Current Zoning: I-1 LWPA (Light Industrial, Lake Wylie Protected Area), B-2 LWPA (General Business, Lake Wylie Protected Area), R-3 LWPA (Single Family Residential, Lake Wylie Protected Area)
Proposed Zoning: R-12MF(CD) LWPA

Approximately 24.13 acres located on the south side of Mount Holly Road east of the intersection with Creston Circle.

The petition proposes to allow redevelopment of a site currently occupied with three single family dwellings, a triplex residential building, and two small commercial buildings with a multifamily residential community of up to 288 dwelling units.

Staff does not recommend approval of this petition in its current form. Staff may reevaluate its recommendation with a reduction in unit count and development outcomes that better align with the Neighborhood 1 Place Type.

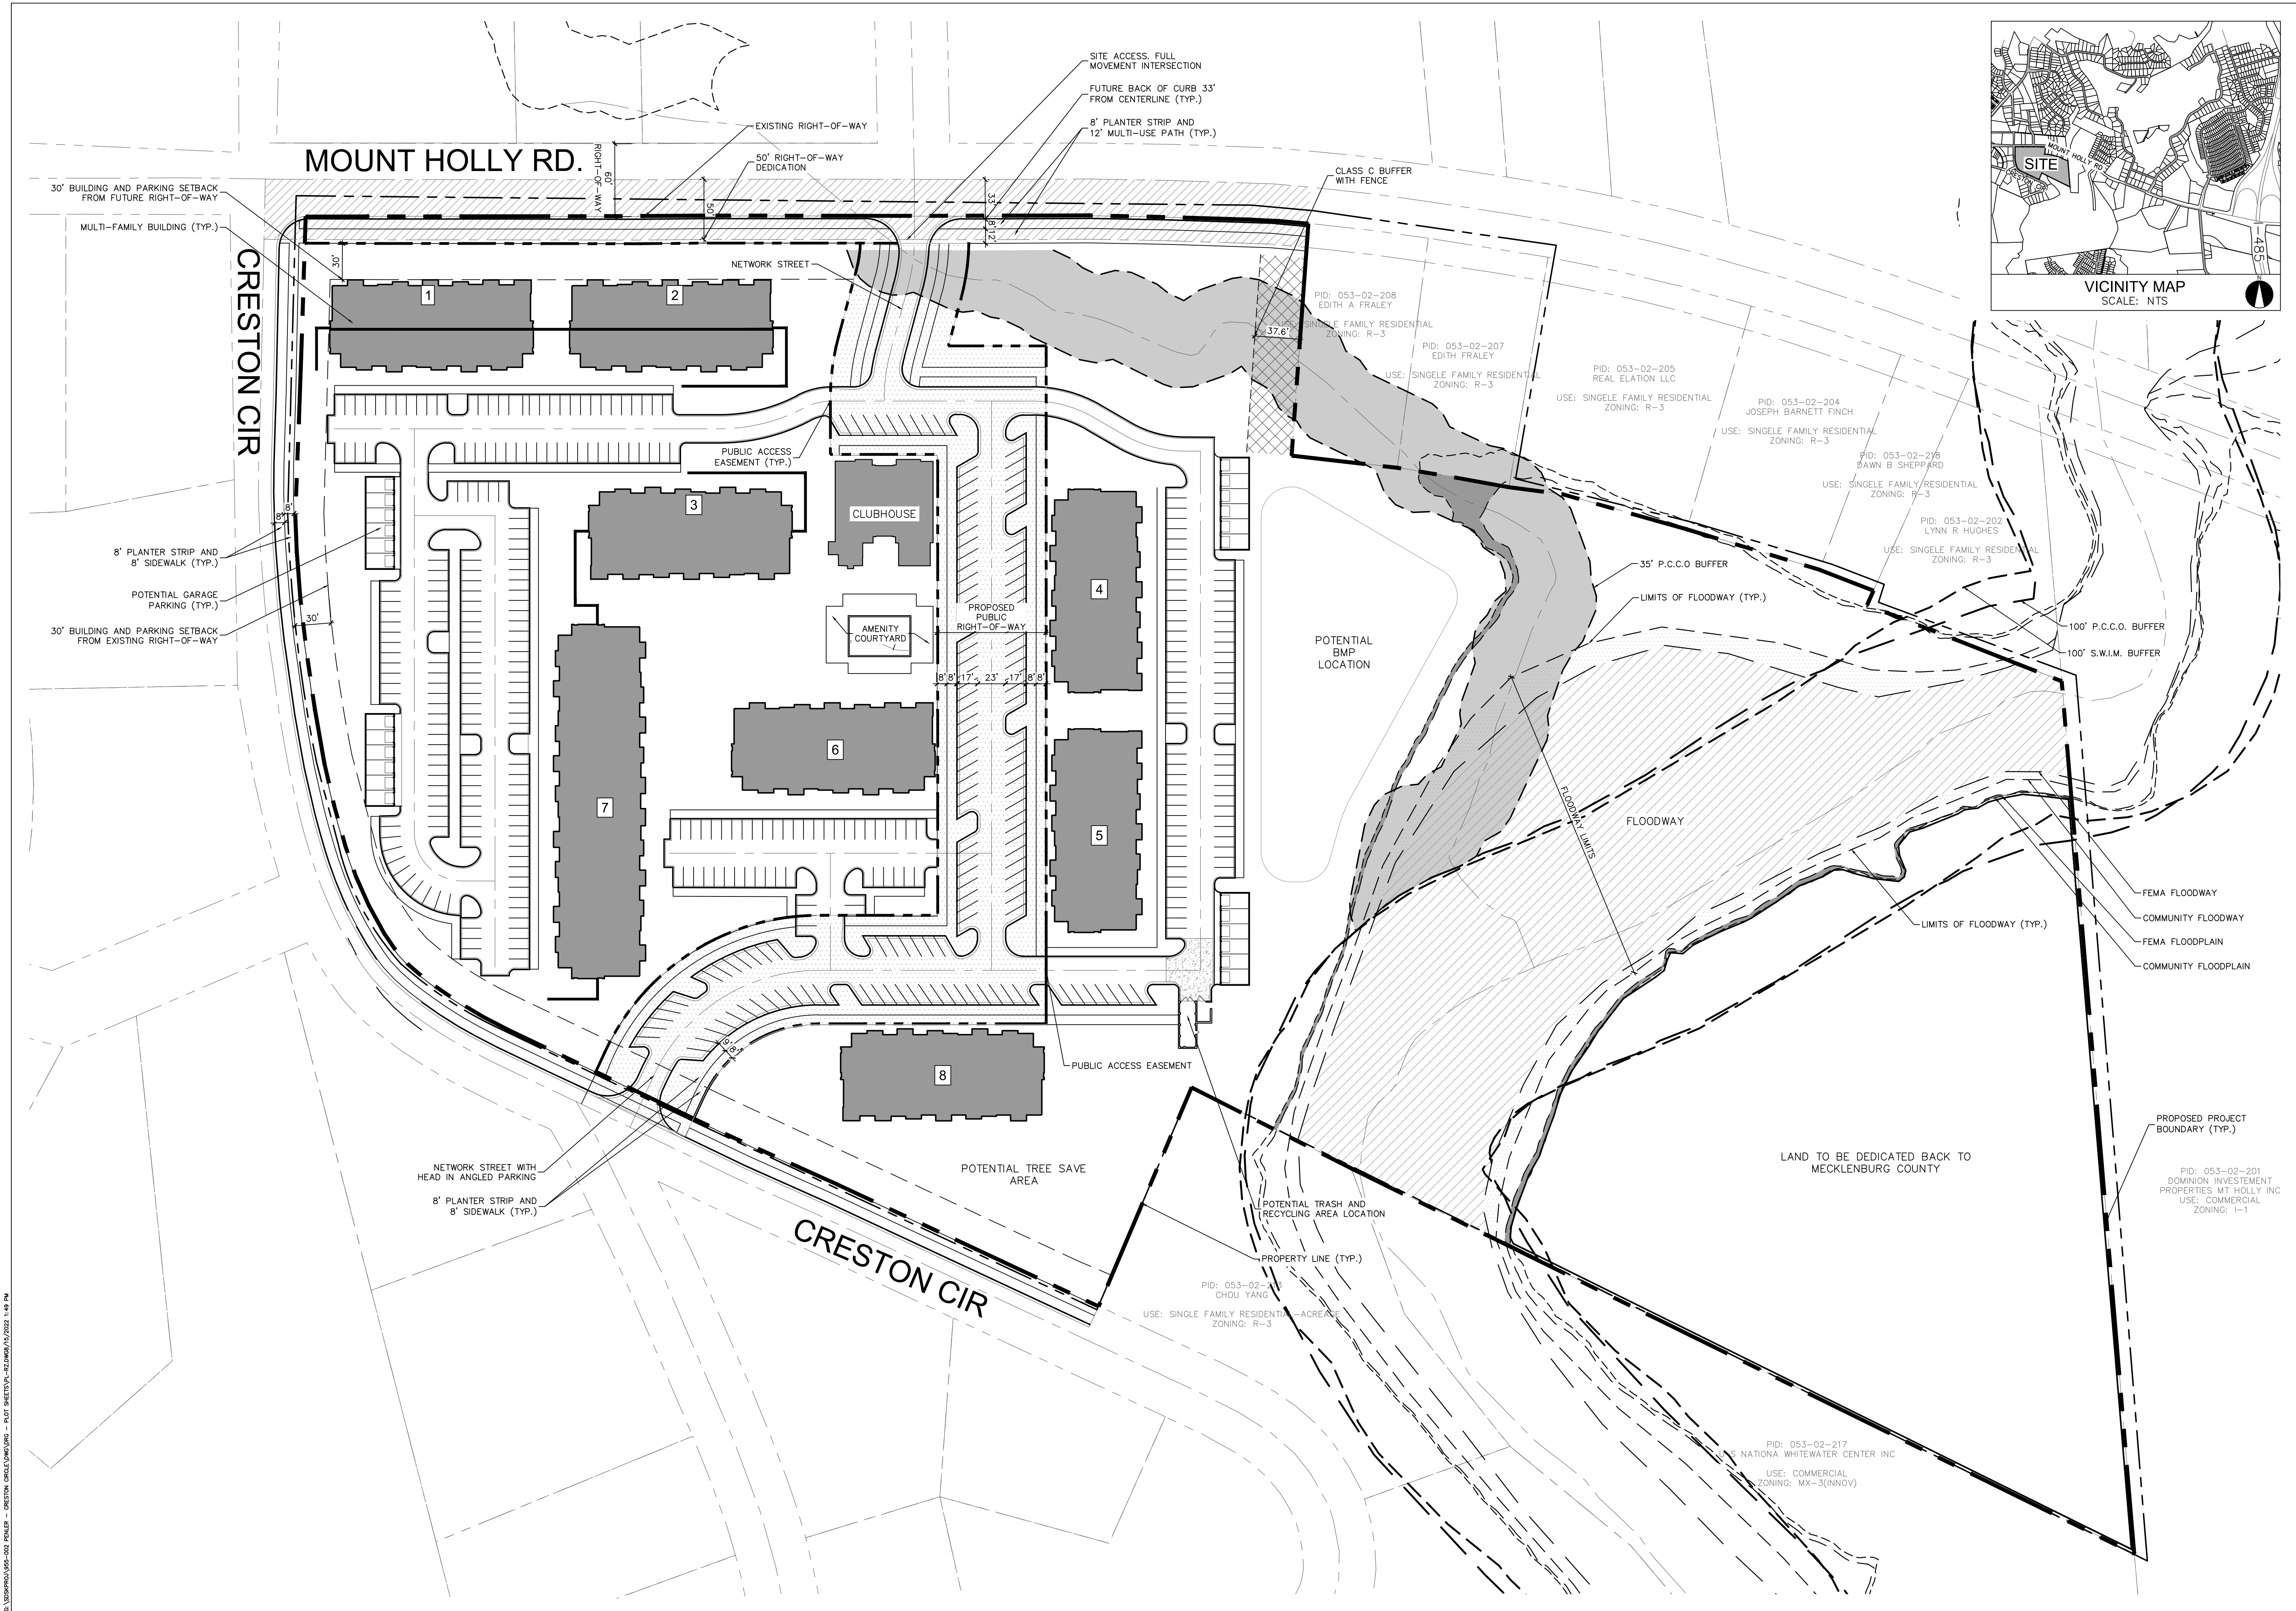
1. Label and dimension the Mount Holly Road future back of curb at 33' for entire Mount Holly Road frontage. Label and dimension the Creston Circle curb and gutter to be installed at 17.5' from centerline in accordance with the Local Residential Wide typical section (CLDSM U-03).
2. Revise site plan and conditional notes to commit to upgrading Creston Circle to the proposed site access in accordance with the Local Residential Wide cross section (CLDSM U-03).
3. Remove or modify the proposed phasing for the development (Note J). Creston Road improvements need to be completed prior to first CO for the site, or a more balanced phasing plan needs to be proposed. The current proposed phasing based on CO for building 8 leaves too much public infrastructure work outstanding for the last building based on the overall project scope, and it is not proportional.

4. Extend the proposed greenway access easement to the public street right-of-way so that Mecklenburg County can access the dedicated parcel area.
5. Provide a tree survey identifying all trees of 8" DBH or greater and all planted trees of 2" caliper or greater and 6' in height that grow partially or wholly within the city right-of-way.
6. Label tree save on the site. The tree save area must be outside of the area to be dedicated to Mecklenburg County.
7. Ensure that all parking spaces and garages are outside of the setback.
8. Ensure that the buildings meet the 27' or 30' setback due to lack of entries on the street elevation.

9. Revise site plan and conditional notes to a building type that better aligns with the Neighborhood 1 Place Type.
